Consultation Response from: KC Environmental Health (Pollution & Noise Control)		
2026/90818 adj, Ash House, 240, Dunford Road, Holmfirth, HD9 2SJ		
Erection of detached dwelling		
Date Responded: 12th June 2026	Responding Officer: KB	Responding Ref: WK/202616553
Foul Drainage It is unclear whether the development has access to a mains drainage system, and no detailed information has been provided regarding the proposed foul water drainage system although we understand from the application form that the proposals may include a package treatment plant (PTP). Before the application can be determined, the applicant must submit detailed information demonstrating how a satisfactory foul drainage system will be provided. This information should confirm the location and capacity of the PTP to ensure it is adequate for the proposed development. Contaminated Land As part of the application 2026/90818, a Phase 1 Environmental Desk Study Report by RGS (16/03/2026 - C5652/25/E/8788) has been received. The report includes geotechnical information, which is outside the remit of Environmental Health, this consultation response therefore relates only to land contamination. We have read and reviewe

TITLE
**PROPOSED DWELLING
 FLOOR PLANS
 & ELEVATIONS**

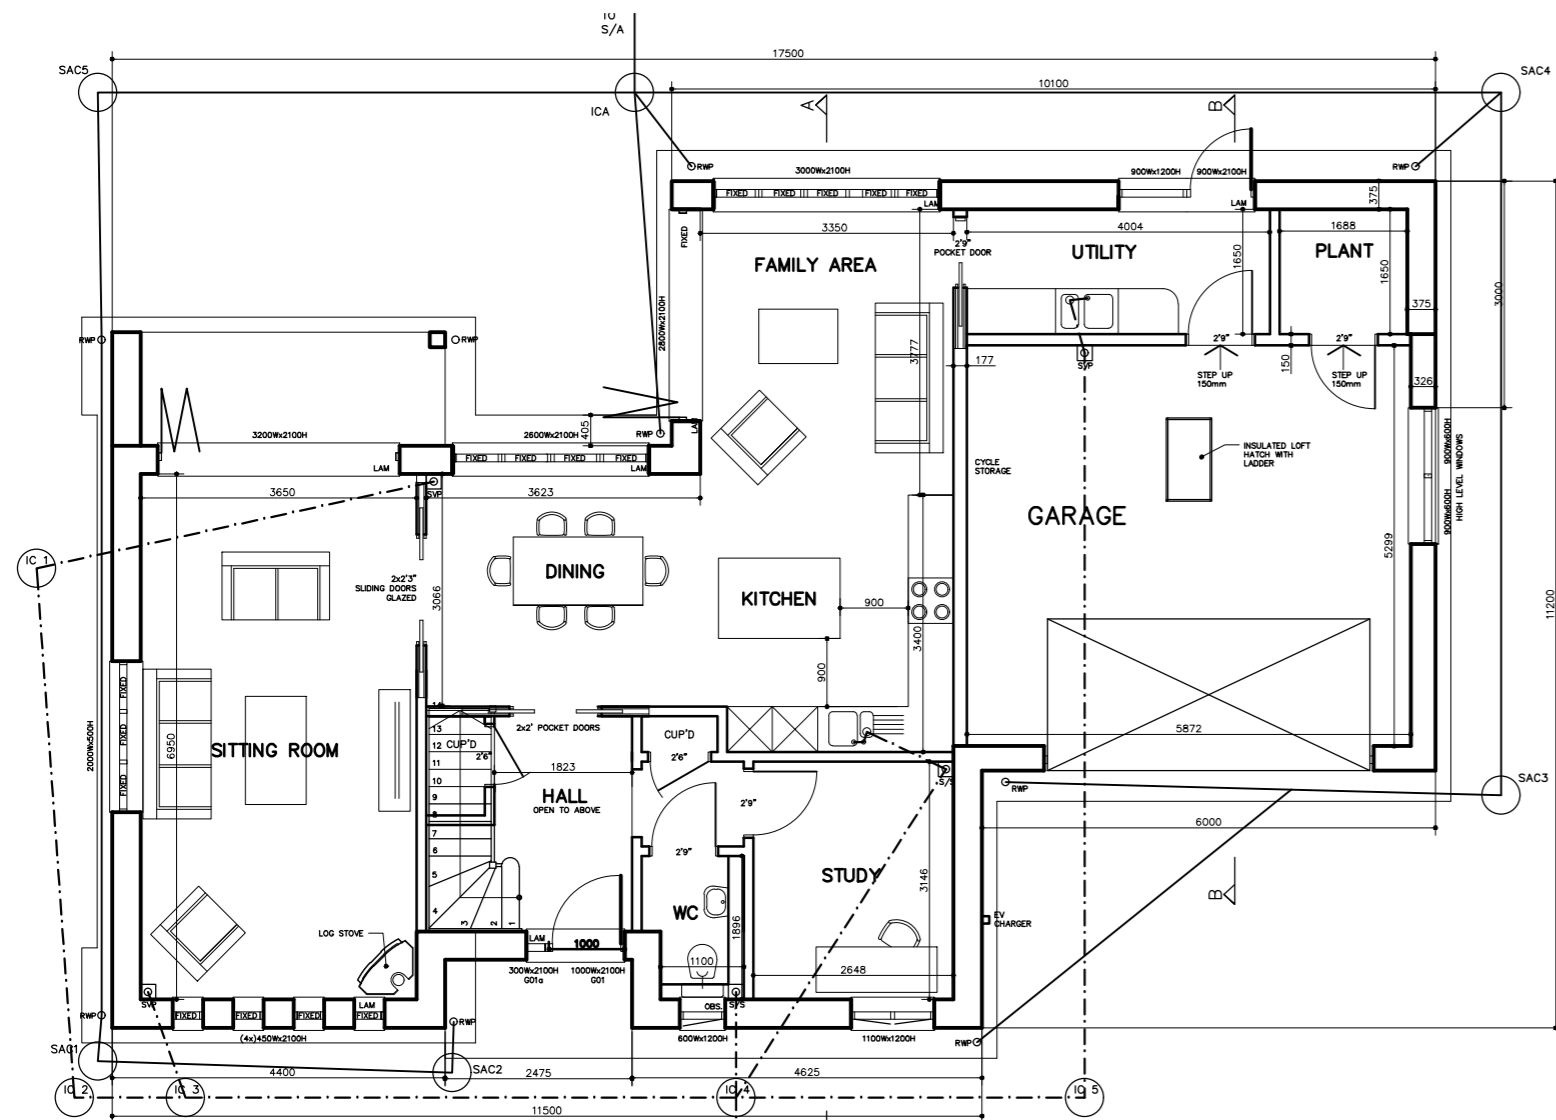
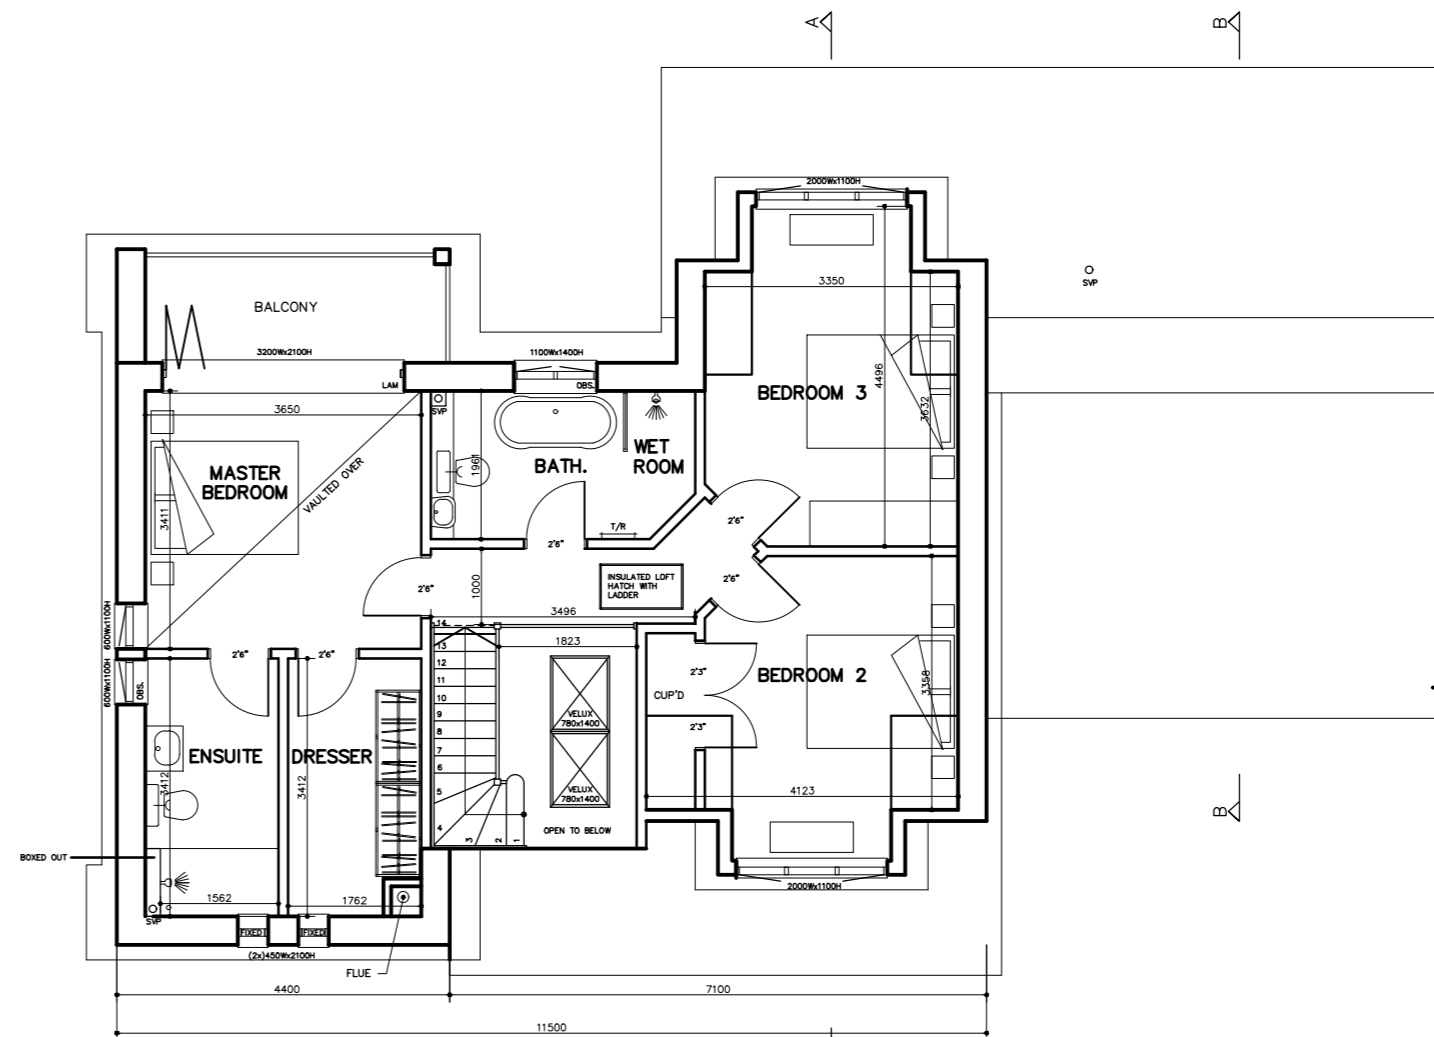
We require information in relation to foul drainage for this development. However, if the applicant can demonstrate that mains sewer connection is available, then the following conditions apply. If the applicant provides additional information in relation to a package treatment plant, we recommend that there is further discussion with Environmental Health before the following conditions are considered as part of the permission.

Before the application can be determined, the applicant must submit detailed information demonstrating how a satisfactory foul drainage system will be provided. This information should confirm the location and capacity of the tank to ensure it is adequate for the proposed development. We require this information to prevent potential pollution of the local environment, in accordance with the Kirklees Local Plan (LP34 and LP52) and Chapter 15 of the National Planning Policy Framework.
